RE: SSD 13_6010 - SICEEP Student Accommodation Response to Submissions

I write in relation to the Department's letter dated 14 January 2014 which enclosed Darling Harbour Live's Response to Submissions regarding State Significant Development Application SSD 6010. This proposal is for one student accommodation building within the West Plot of the future Haymarket Precinct in Darling Harbour.

Figure 3.5.1 Darling Drive

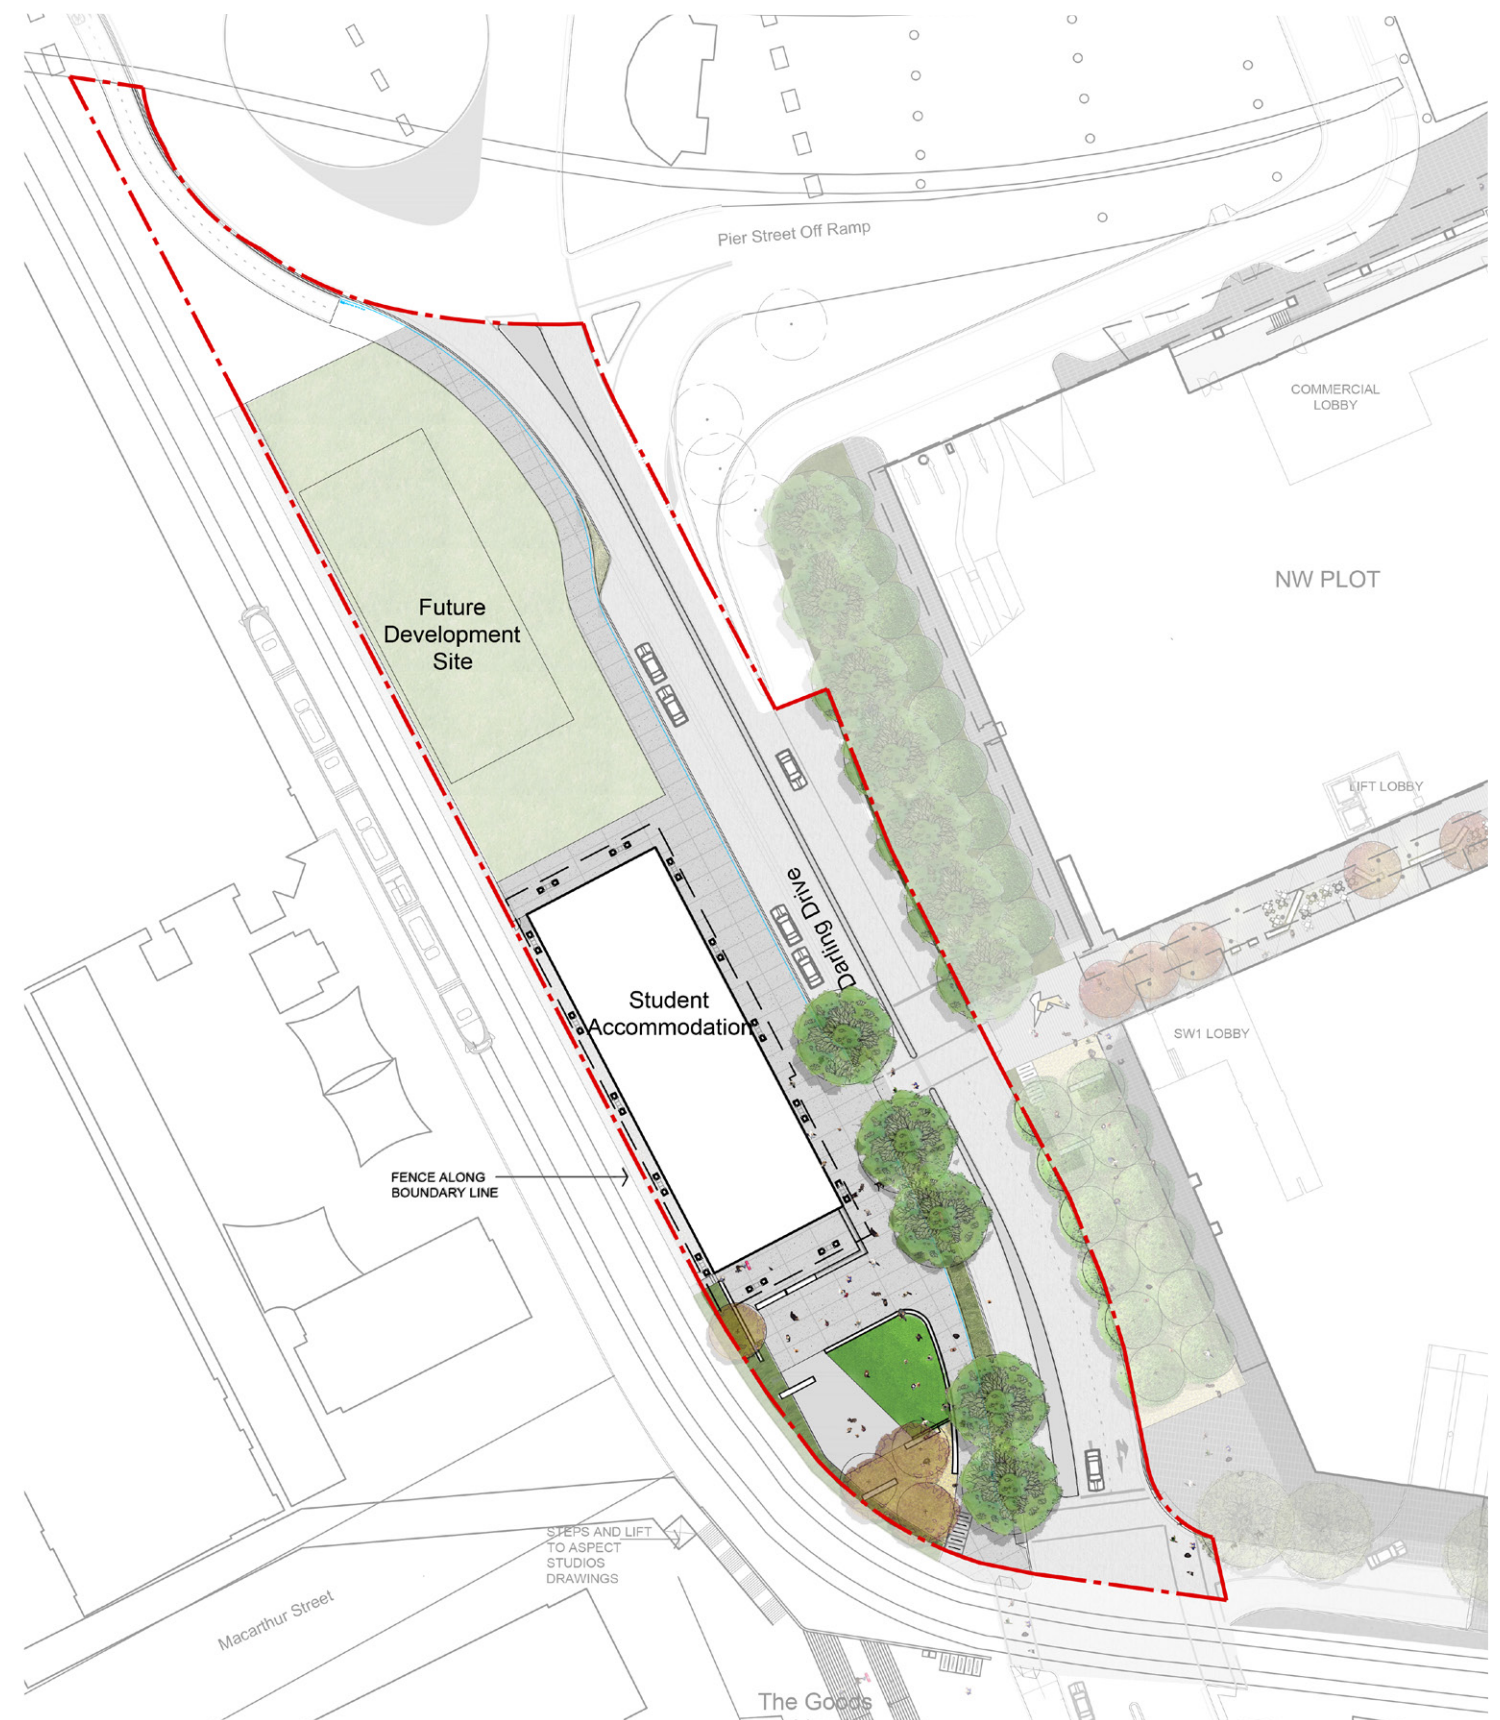
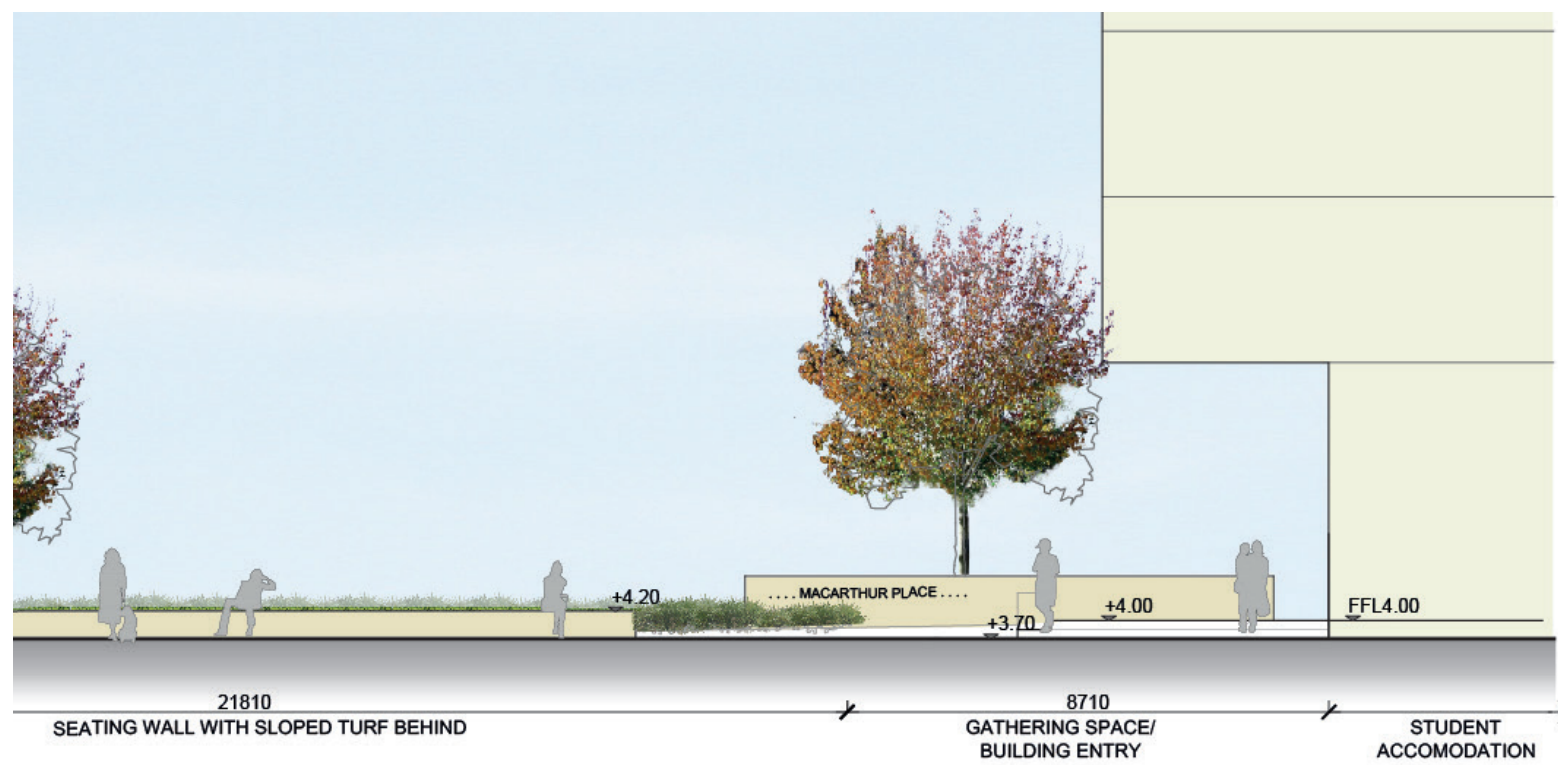
- The vehicle layover along Darling Drive in front of the proposed building plots. The layover should be reduced in length and the partial street tree planting that has been introduced should be further increased;
- The timing of the proposed development compared to the timing of The Goods Line pedestrian connection and the proposed Hay Street pedestrian improvements. In this regard, it is unclear whether these pedestrian connections will already be in place when the student accommodation opens, or if interim arrangements will be necessary. The City contends that the proposed building should not be occupied until the surrounding essential connecting infrastructure is in place;
- Bike parking spaces should be increased to match the requirements of Sydney Development Control Plan 2012 and allow for future growth in bicycle use;

- The residential floor-to-floor heights should be increased to at least 3.05m to allow for a minimum 2.7m floor-to-ceiling height; and
- A continuous ground level colonnade/awning should be provided along Darling Drive for pedestrian comfort to the proposed building, the future northern student accommodation tower and the Exhibition Light Rail Station.
